May 15, 2014

RE: Harnett County Land Use Existing Tank Application # 14-5-33607

Based on the criteria set out in Title 15A, Subchapter 18A, of the North Carolina Administrative Code, Rules .1950, the evaluation indicated that the site is **UNSUITABLE** for the addition requested. Therefore, your request for an existing tank is **DENIED**. The site is denied based on the following:

PROPOSED PLAN FOR
DAWSON CONSTRUCTION
 15 CURRAGH COVE
 FUQUAY - VARINA, NC 27526
 LOT 1 MAGNOLIA CREST SUBDIVISION
 MAP # 2007 - 39
 PIN # 0855-52-4335.000
 HECTOR'S CREEK TOWNSHIP
 HARNETT COUNTY - NORTH CAROLINA
 SCALE : 1" = 50' - DEC. 26, 2012

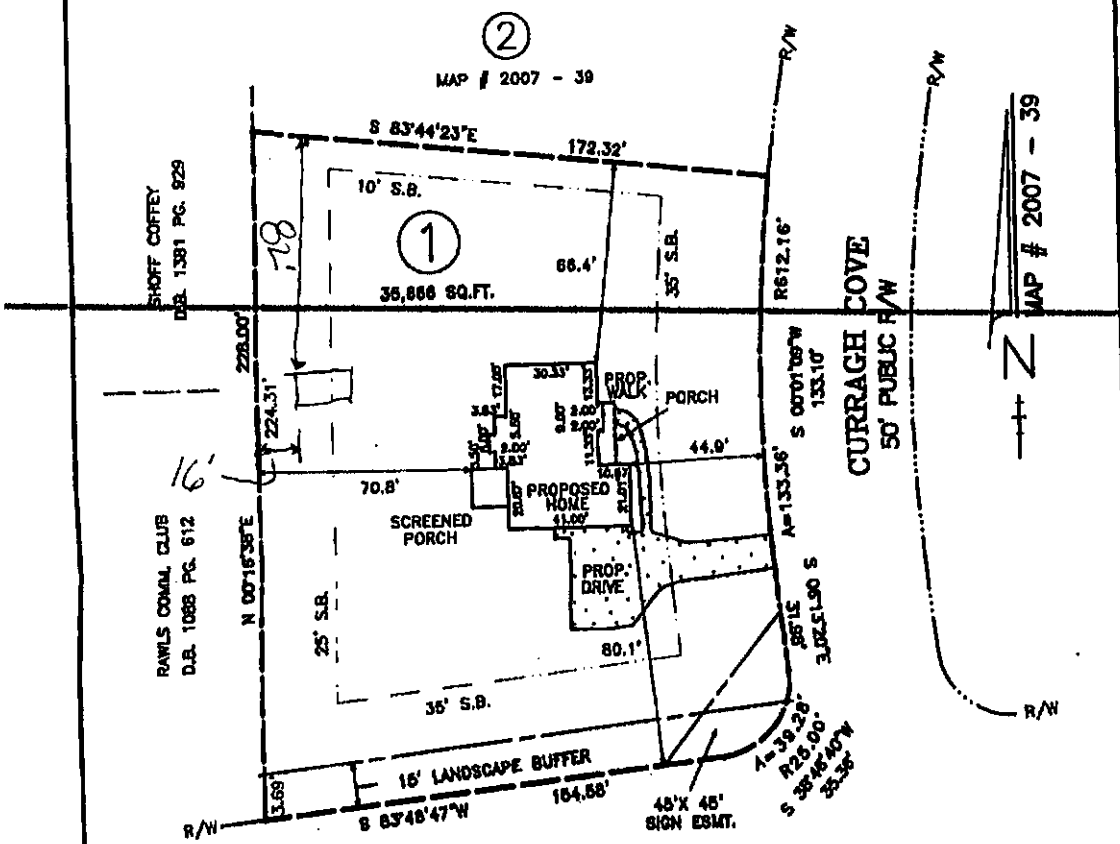
- 15A NCAC 18A.1950a {16} - Any swimming pool must be 15' from any part of septic system.
- 15A NCAC 18.1945{b} - Each lot shall have original septic system plus repair area.
- 15A NCAC 18A.1950 {10} - Any building to be 5' from septic tank and/or from drain line.
- 15A NCAC 18A.1950{c} - Nitrification fields and repair areas shall not be located under paved areas or areas subject to vehicular traffic.

Your proposed building will be positioned on top of your drain lines and will need to be moved if possible.
